**KIRKLEES METROPOLITAN COUNCIL
INVESTMENT & REGENERATION SERVICE**

Reference No:	2023/62/92729/E
Site Address:	90, The Crescent, Ravensthorpe, Dewsbury, WF13 3BA
Description:	Erection of two storey side extension
Recommending Officer:	Jennifer Booth

DECISION - REFUSED

OFFICER REPORT

PROPOSED GROUND FLOOR PLAN

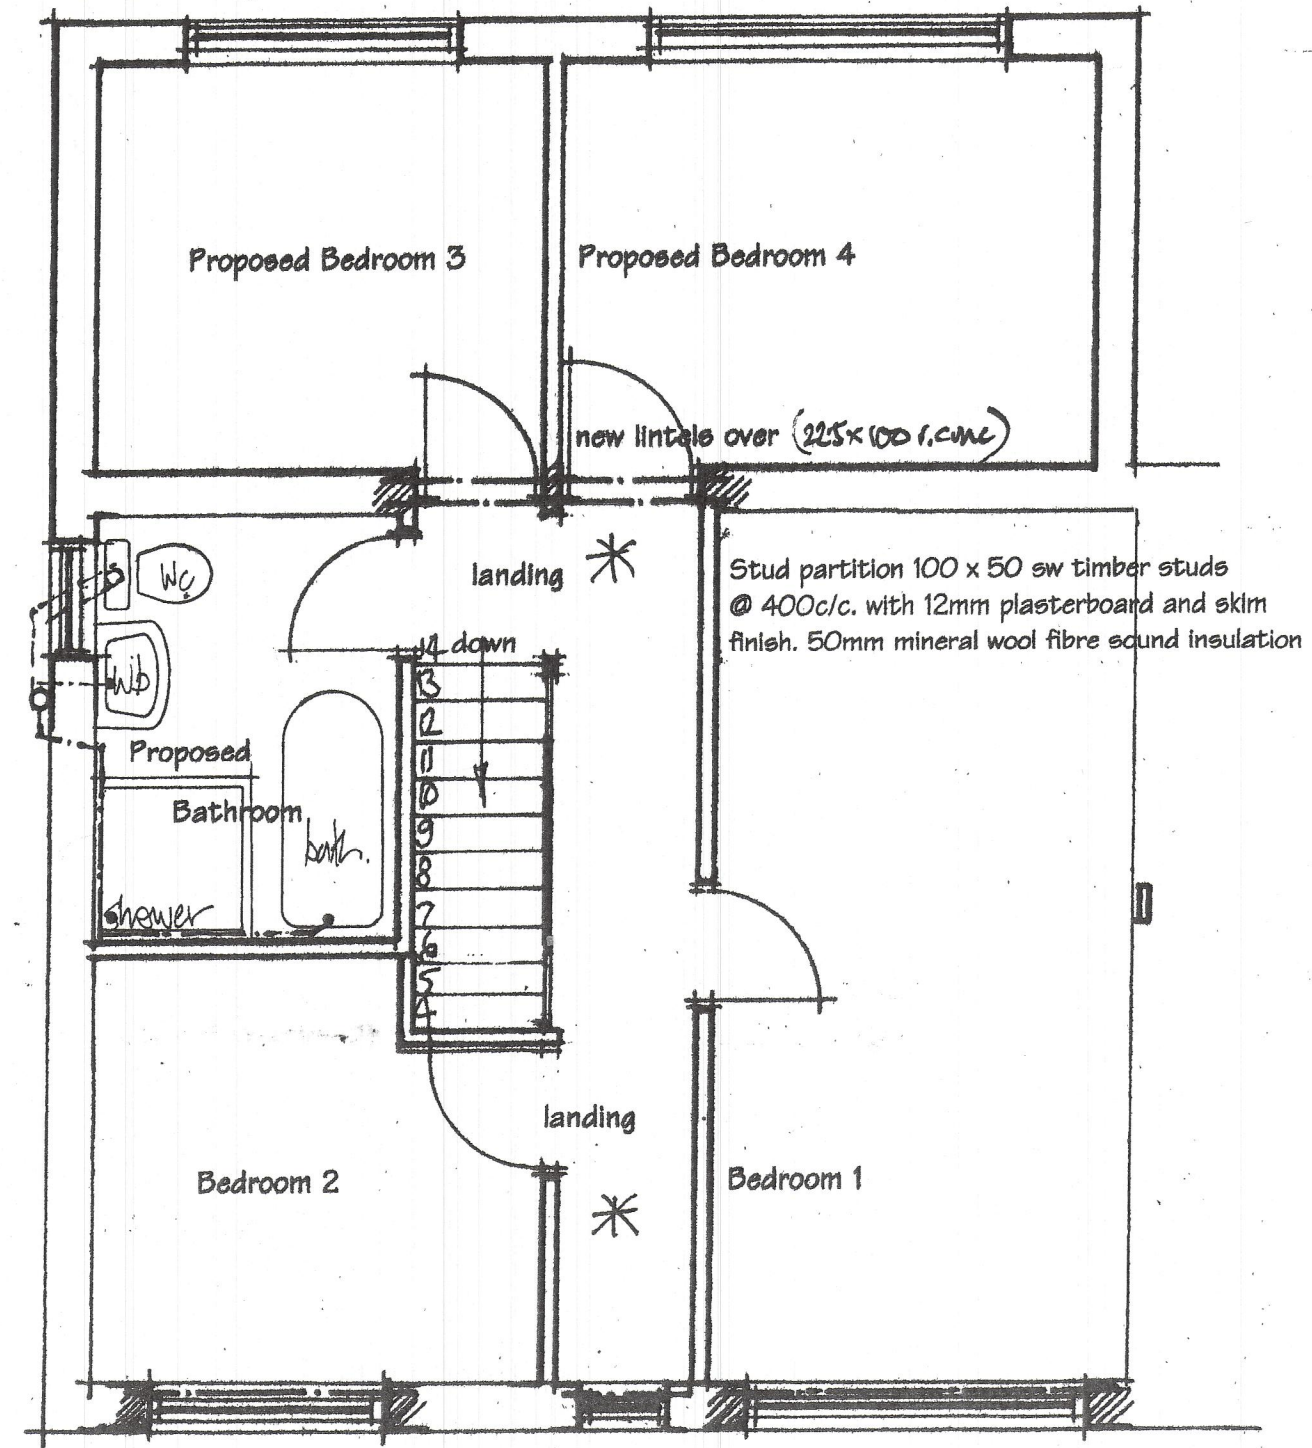
The extension would be set back 0.4m from the front wall of the dwelling extending back 12m on the ground floor and 9m at first floor to align with the rear of the dwelling, as extended. The roof at the side would be a set down hipped roof, with a smaller hip over the rear element at first floor level and a lean to over the single storey element.

The side extension is shown on plan with no set back or set down and would be constructed up to the property boundary taking up all of the gap contrary to point 5.20 of the HESPD. The extension proposed would not be subservient in relation to the host dwelling. Furthermore, the cumulative impact of the proposed extension with the existing single and two storey extension to the rear of the dwelling and the large, detached outbuilding, the property would be overdeveloped. Despite the use of matching materials, the impact on the host property and wider street scene is not considered to be acceptable.

PROPOSED SIDE ELEVATION

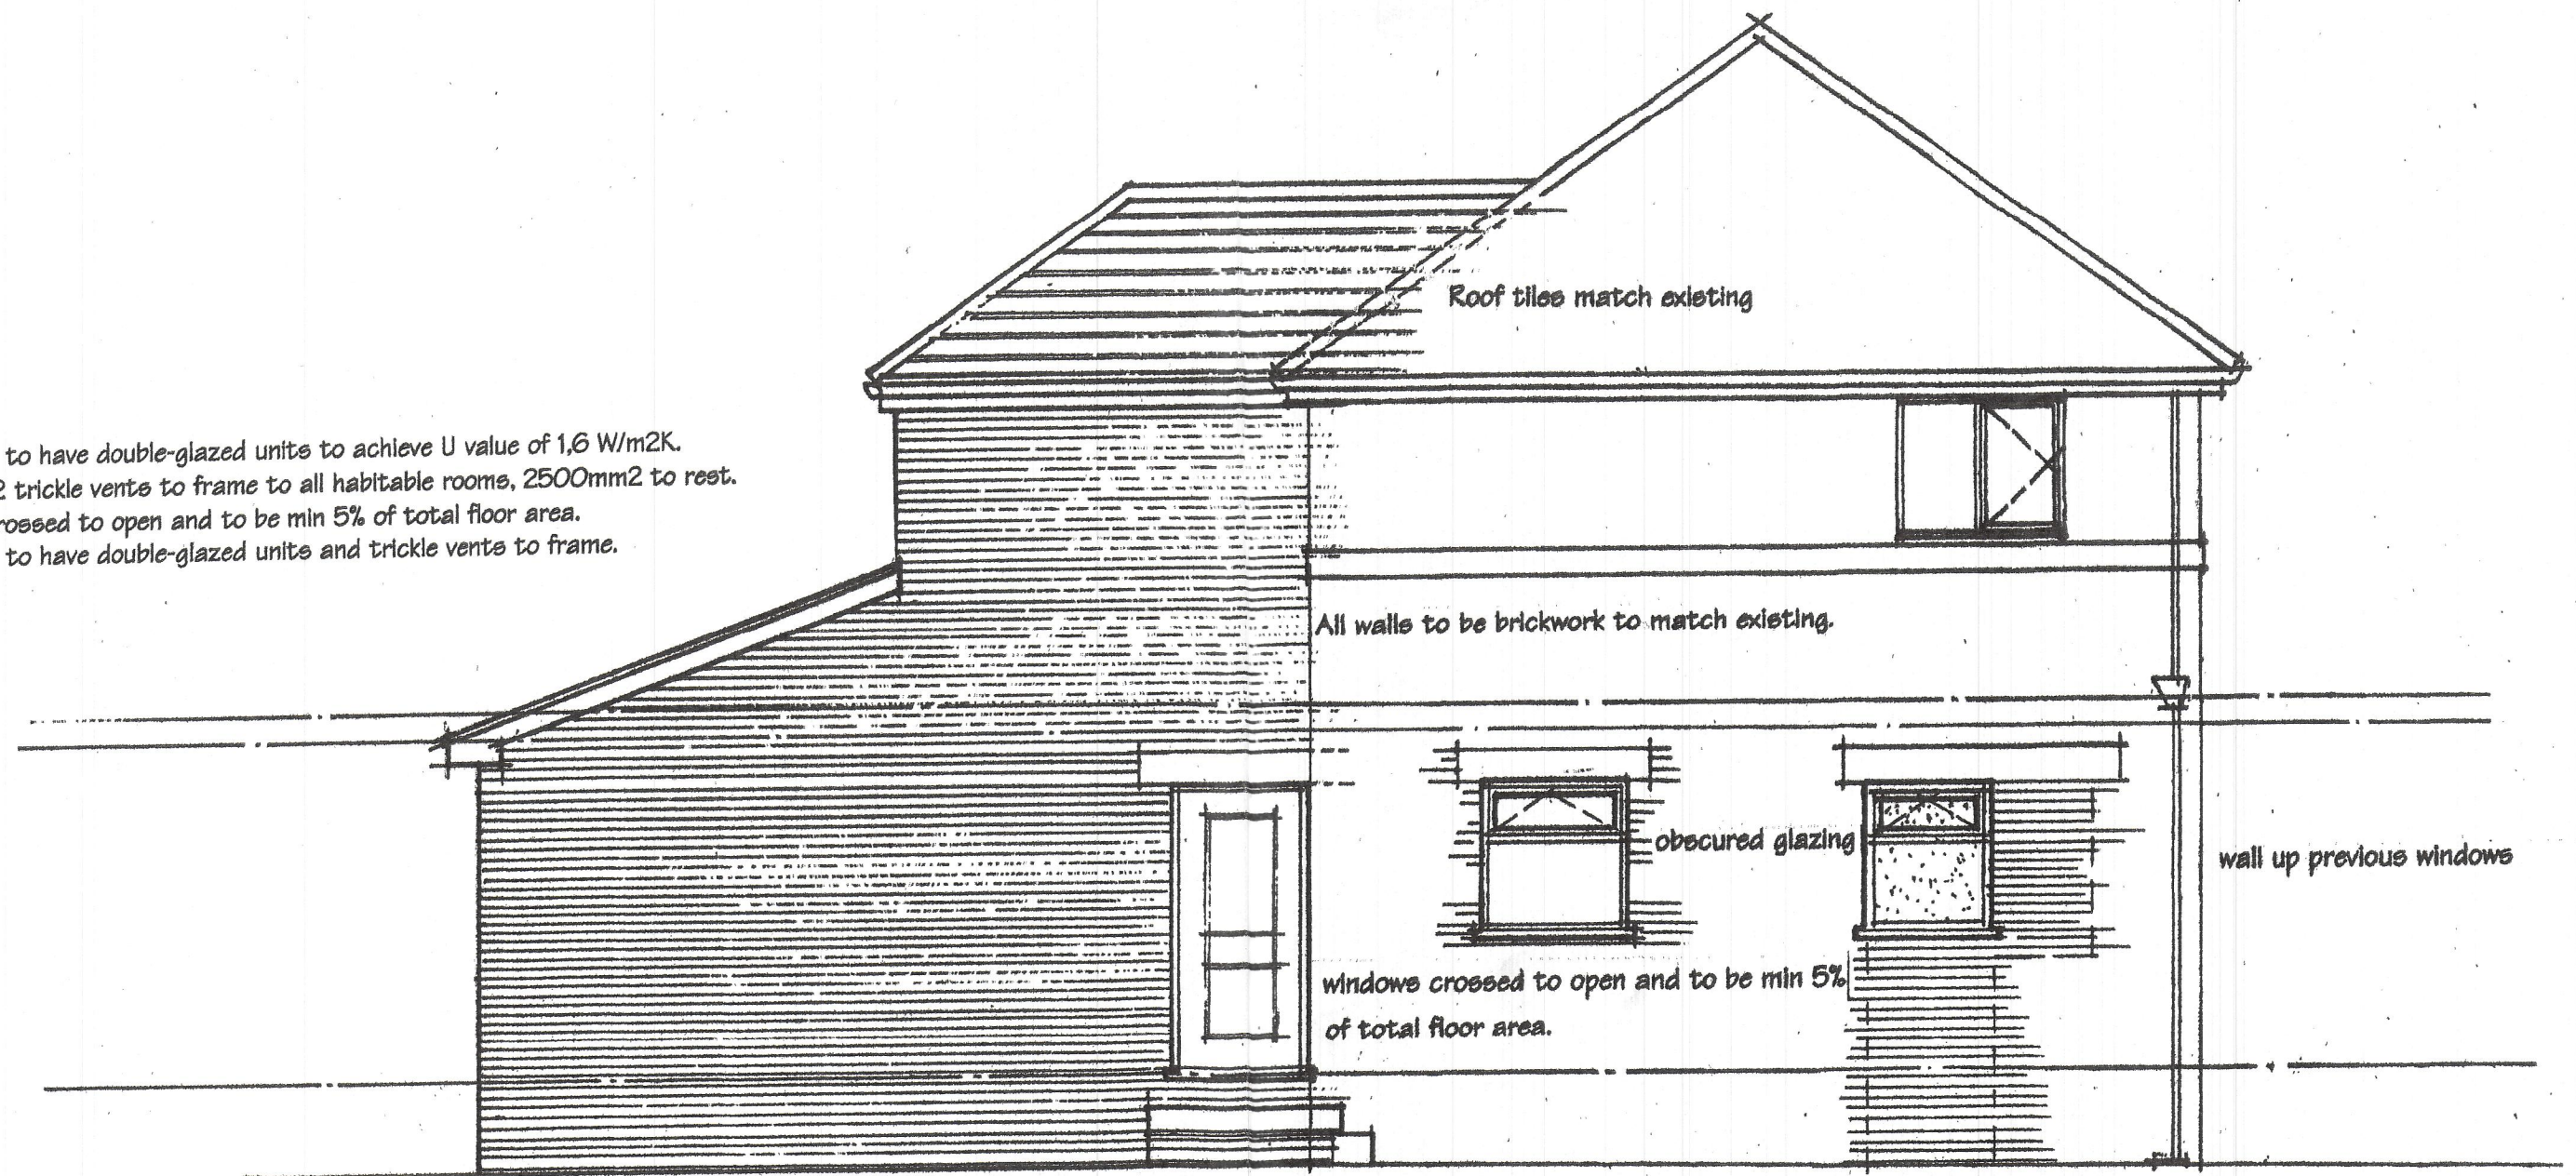
1. The proposed two-storey side extension, due to design and scale would not form a subservient addition to the host dwelling and would take up all or most of the space to the side of the house failing to maintain a 1.0 metre gap to the side boundary to ensure the building is not too close to a neighbouring property. As such it would appear incongruous, closing the gap between the houses thereby eroding the sense of space to the detriment of the street-scene. This does not promote good design and is contrary to Policy LP24 of the Kirklees Local Plan and design guidance given in sections 4.1, 4.2, 4.3, 5.19, 5.20 & 5.21 of the Kirklees House Extensions Supplementary Planning Document.

~~PROPOSED~~ FRONT ELEVATION

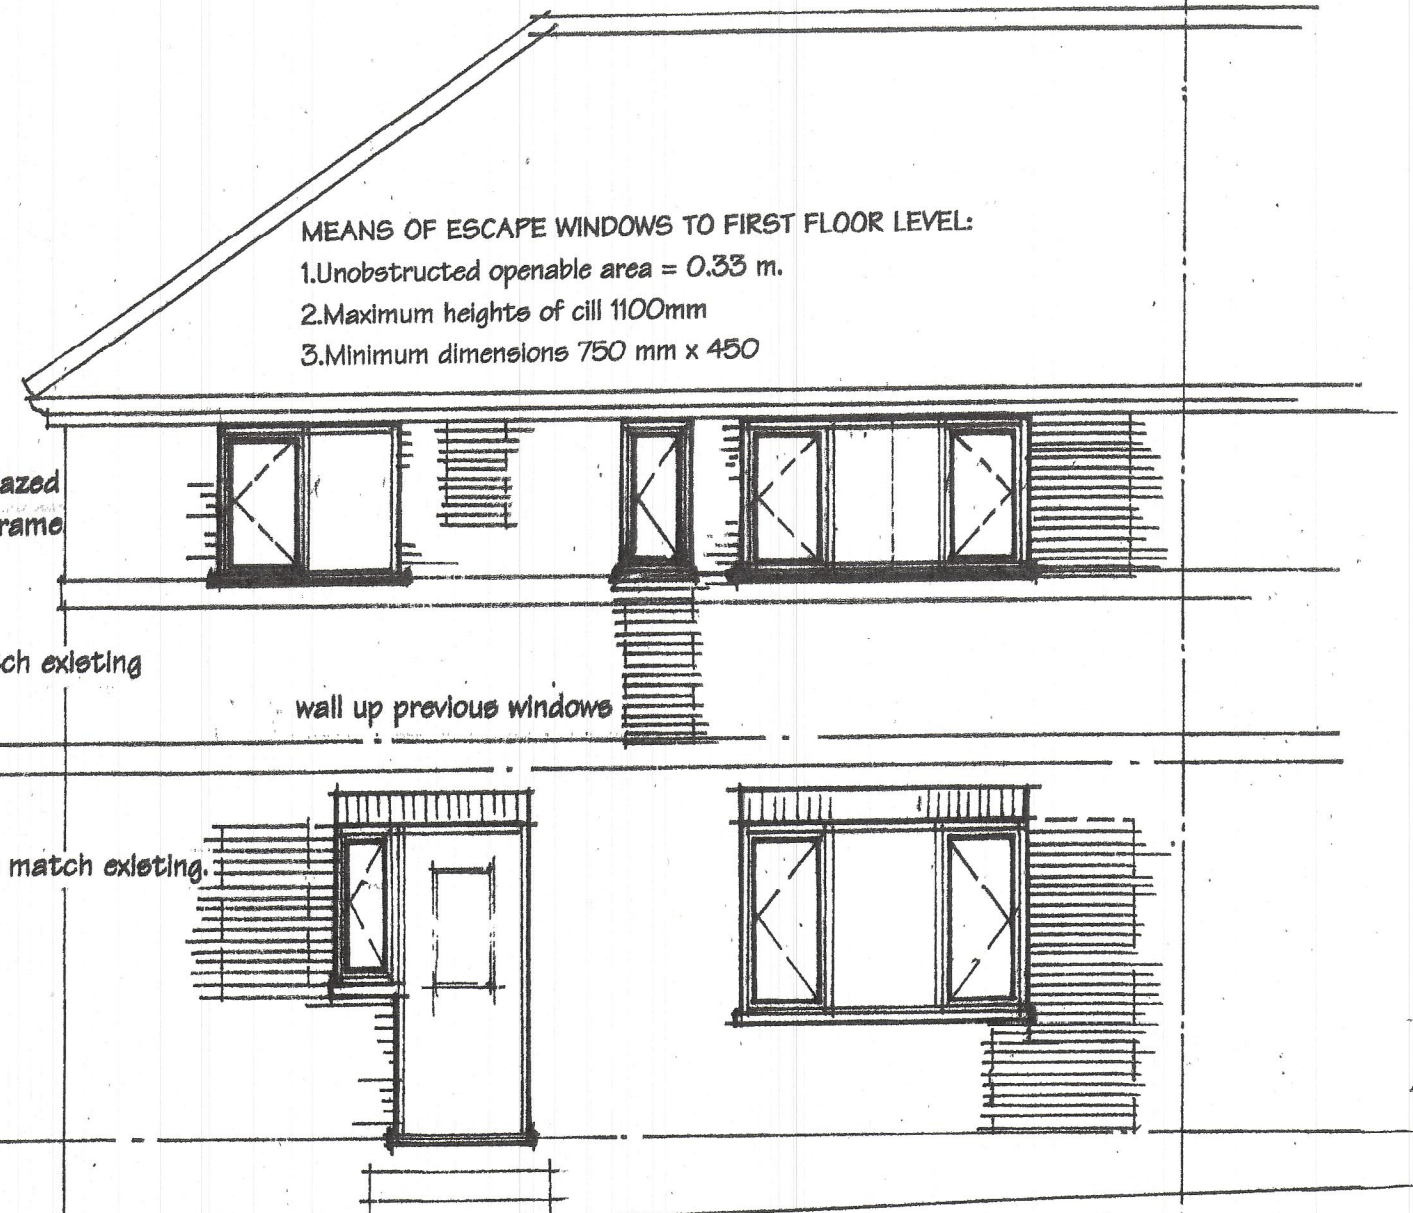
The proposed side extension, by reason of the design and scale, would not form a subservient feature and would result in an incongruous form of development in the wider area. To permit the proposals would be contrary to Policy LP24 of the Kirklees Local Plan, KDP1 and KDP2 of the House Extension SPD and advice within chapter 12 of the National Planning Policy Framework.
